Report of the Head of Strategic Investment

HUDDERSFIELD PLANNING SUB-COMMITTEE

Subject: Planning Application 2017/91505 Outline application for erection of residential development Land off, Huddersfield Road, Meltham, Holmfirth, HD9

PROPOSED ACCESS LAYOUT

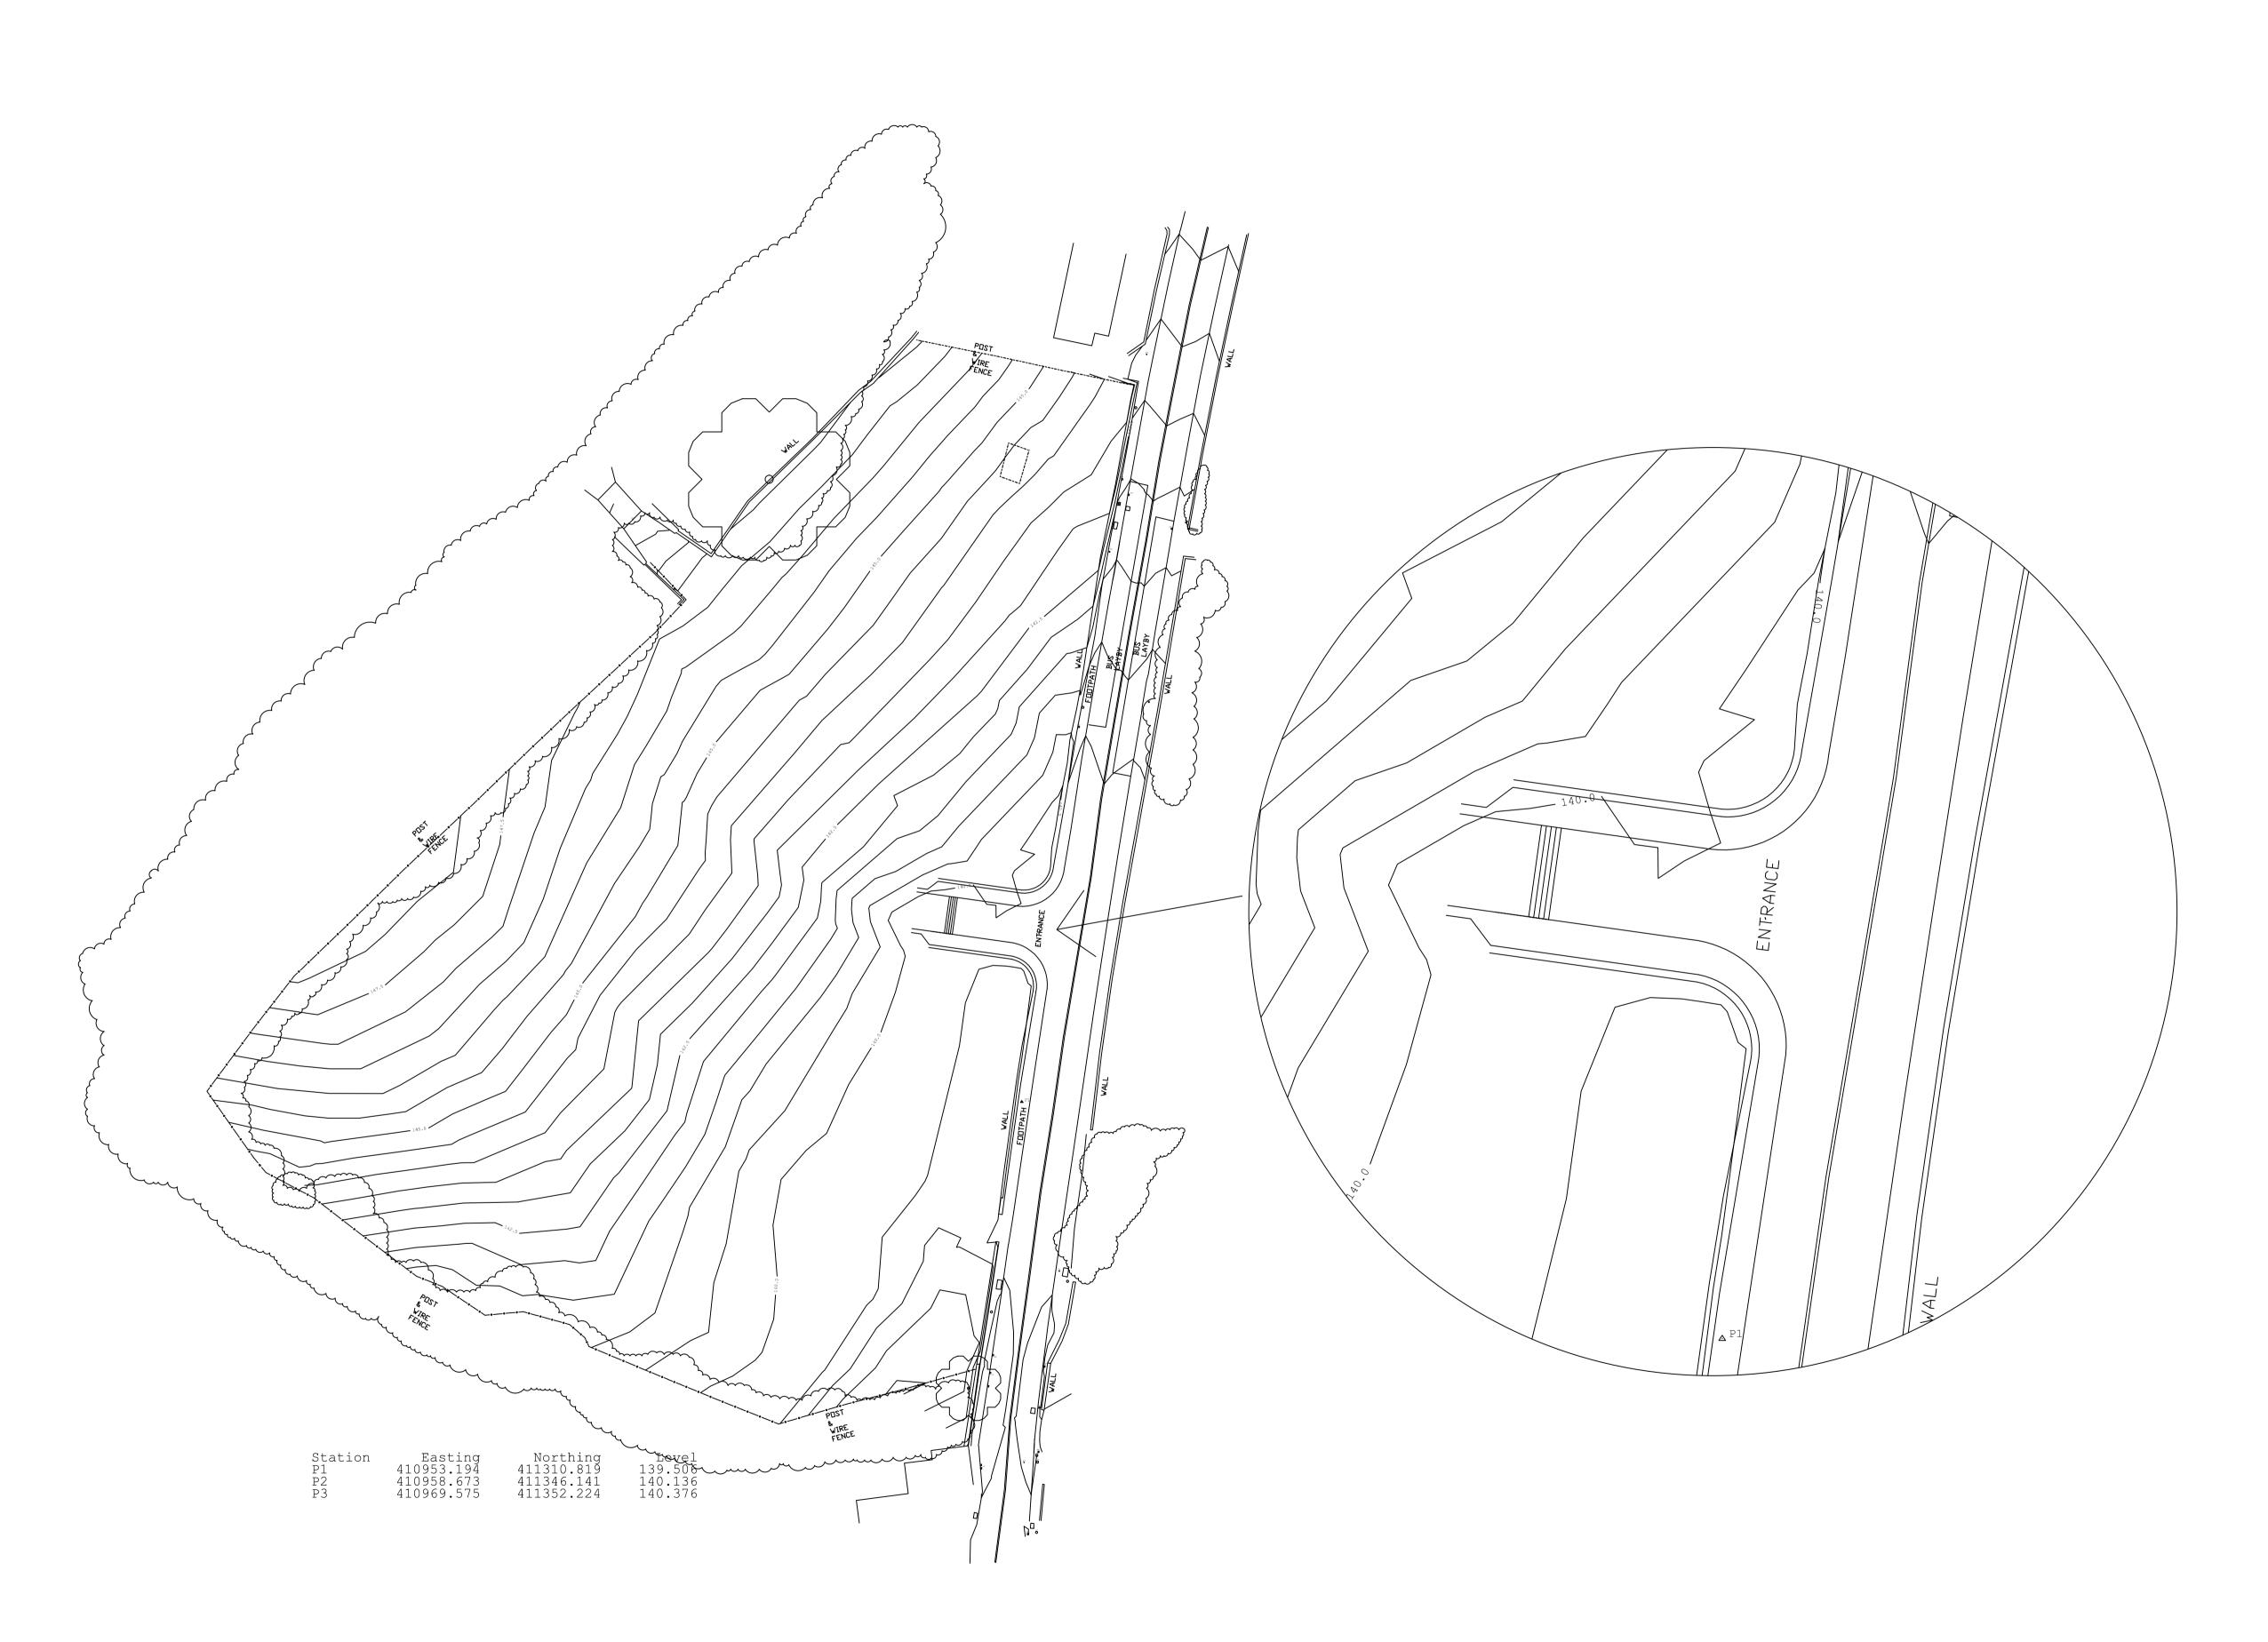
Lead Local Flood Authority – Kirklees Flood Management as LLFA objects to this application as it is unclear as to whether the promoted access on drawing ref 1754/01 “Site Plan with new Vehicular Access” will result in requirements to culvert an open watercourse to gain access to the southern part of the site, contrary to planning policy.

- 10.47 Whilst in principle it appears that the scheme is acceptable in drainage terms, and the access location has been revised in order to avoid direct conflict with the watercourse that runs through the site, an objection has been raised by the Lead Local Flood Authority concerning the potential impact of the scheme on the watercourse and the potential for it to be culverted. It is considered

that these matters would be fully addressed at reserved matters stage in the event that the layout proposes to cross the watercourse running through the centre of the site. There appears to be sufficient space within the site on the upper slopes in order to ensure that conflict with the watercourse is lessened. However, at the time of writing this report the applicant was preparing a response to the concerns raised and these will be reported as an update.
